PLANNING CONSULTATION RESPONSE

Application No	2026/0396
Proposal	Erection of 2 storey detached dwellinghouse and detached double garage
Address	Land to the rear of 108 Blythe Street, Wombwell, Barnsley, S73 8LL
Date of Consultation Reply	17/06/26
Consultee	Highways DC

Ref: 202516 Drwg No: 01

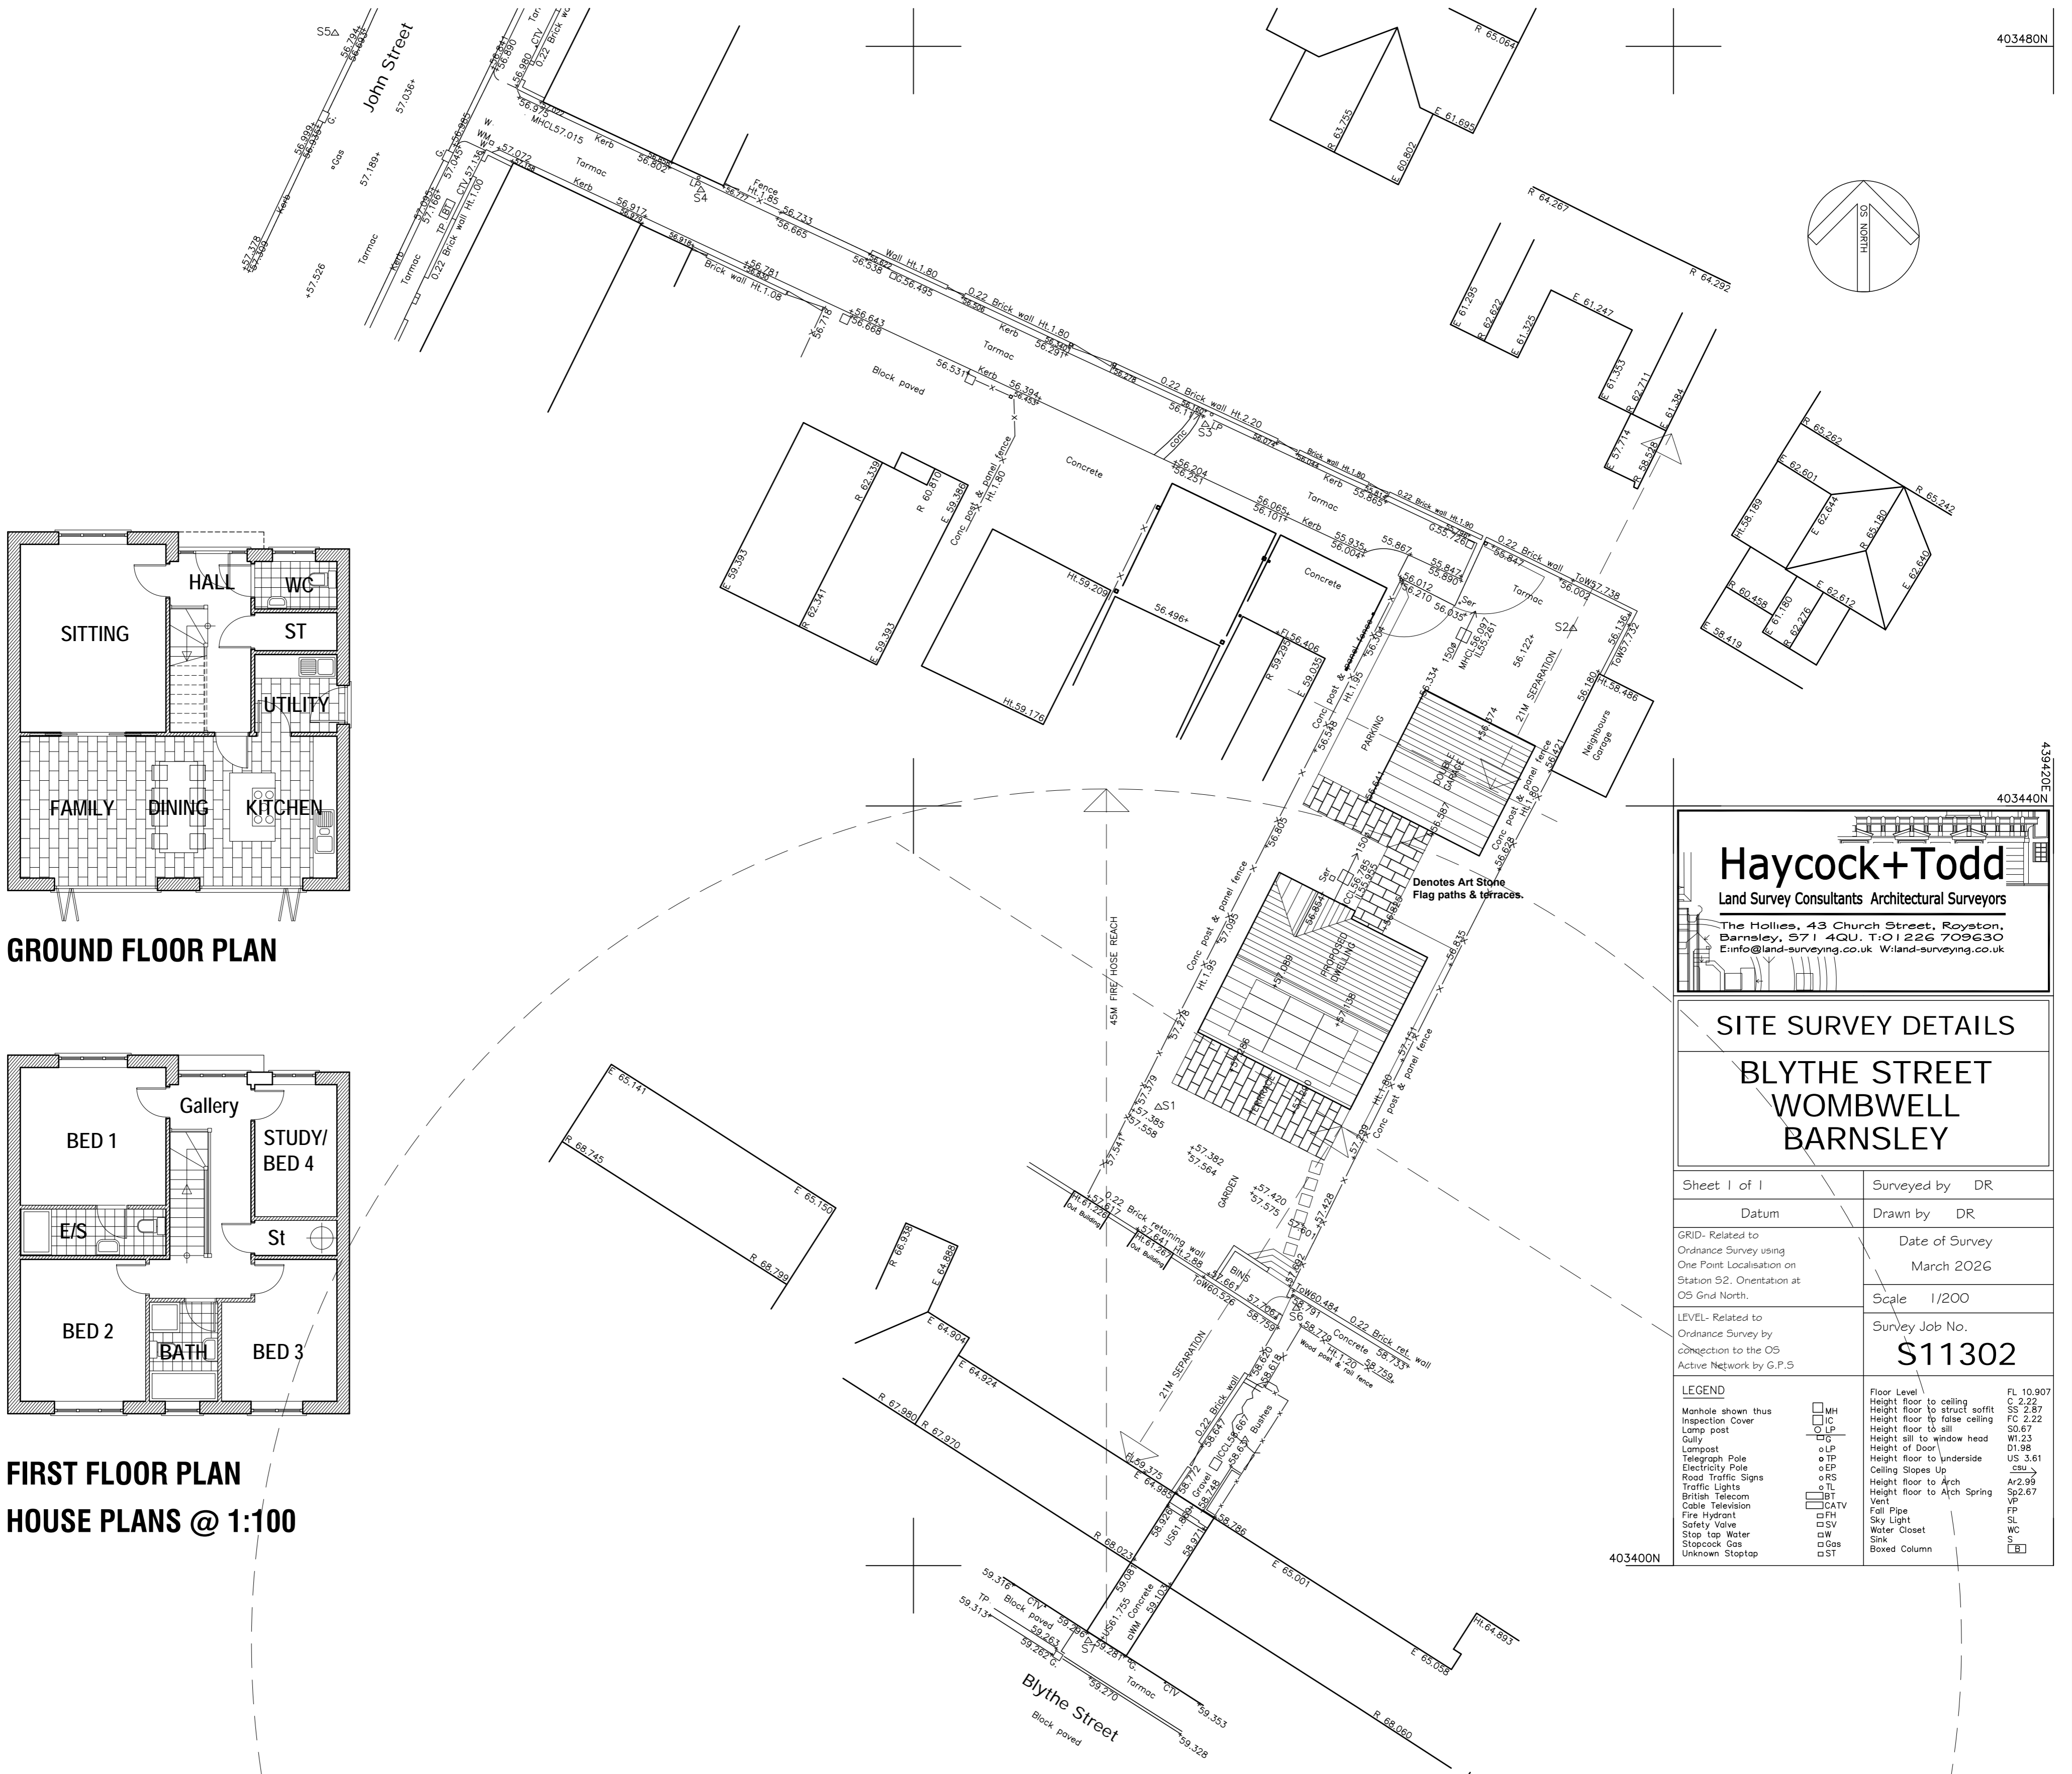
The other concerns raised at the appeal (and by HDC officers at the time) were that the driveway would not permit emergency fire appliance access and that the proposal provided no local authority waste collection strategy. The applicant has tried to address this by providing a route through the undercroft access within the row of terraced dwellings on Blythe Street. However, this doesn't appear to allow access for a pumping appliance to be provided to within 45m of all points inside the dwellinghouse, as stipulated in section 13.1 of Building Regulations Approved Document B – Fire Safety. It is advised that the planning officer contacts the South Yorkshire Fire Service directly if additional advice is required regarding the suitability of this proposed arrangement.

In terms of refuse collection, no pad has been shown for presenting bins adjacent to the public highway. The likelihood is that bins would be presented on, rather than adjacent to, Blythe Street. This would also be a unsuitable solution the to problem.
